Further to our call, please find attached the results of the revised plans to be issued to the Local Authority. I have also added some commentary to assist.

Notwithstanding the above, we have undertaken an exercise looking at some slight revisions which look to improve daylight levels. The changes are detailed below:

Proposed Elevations Crown Close Rear & Station Rd

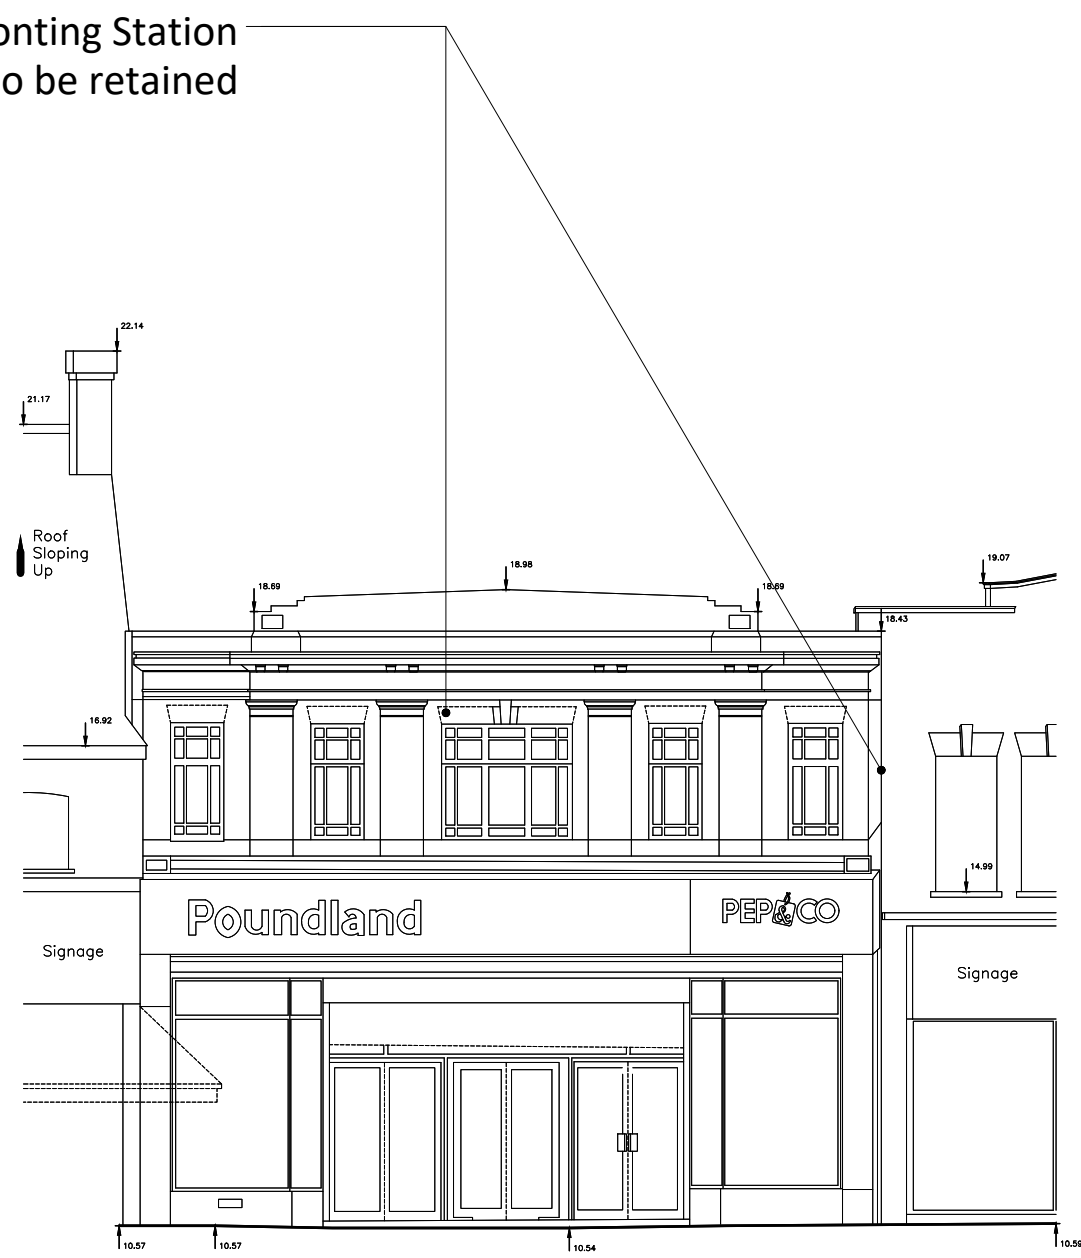
- *Reduction to balcony depth to Apartments along Crown Close within apartments 1F1, 1F3, 1F4, 1F6, 2F1, 2F3, 2F4 and 2F6*
- *Introduction of railings (in lieu of balcony walls) to sides of certain balconies facing onto Crown Close for 1F1, 1F4, 1F6, 2F1, 2F4 and 2F6*
- *Removal of covered balcony for 2nd floor Apartments to increase daylight provision into Living/Kitchen for 2F1, 2F3, 2F4 and 2F6*
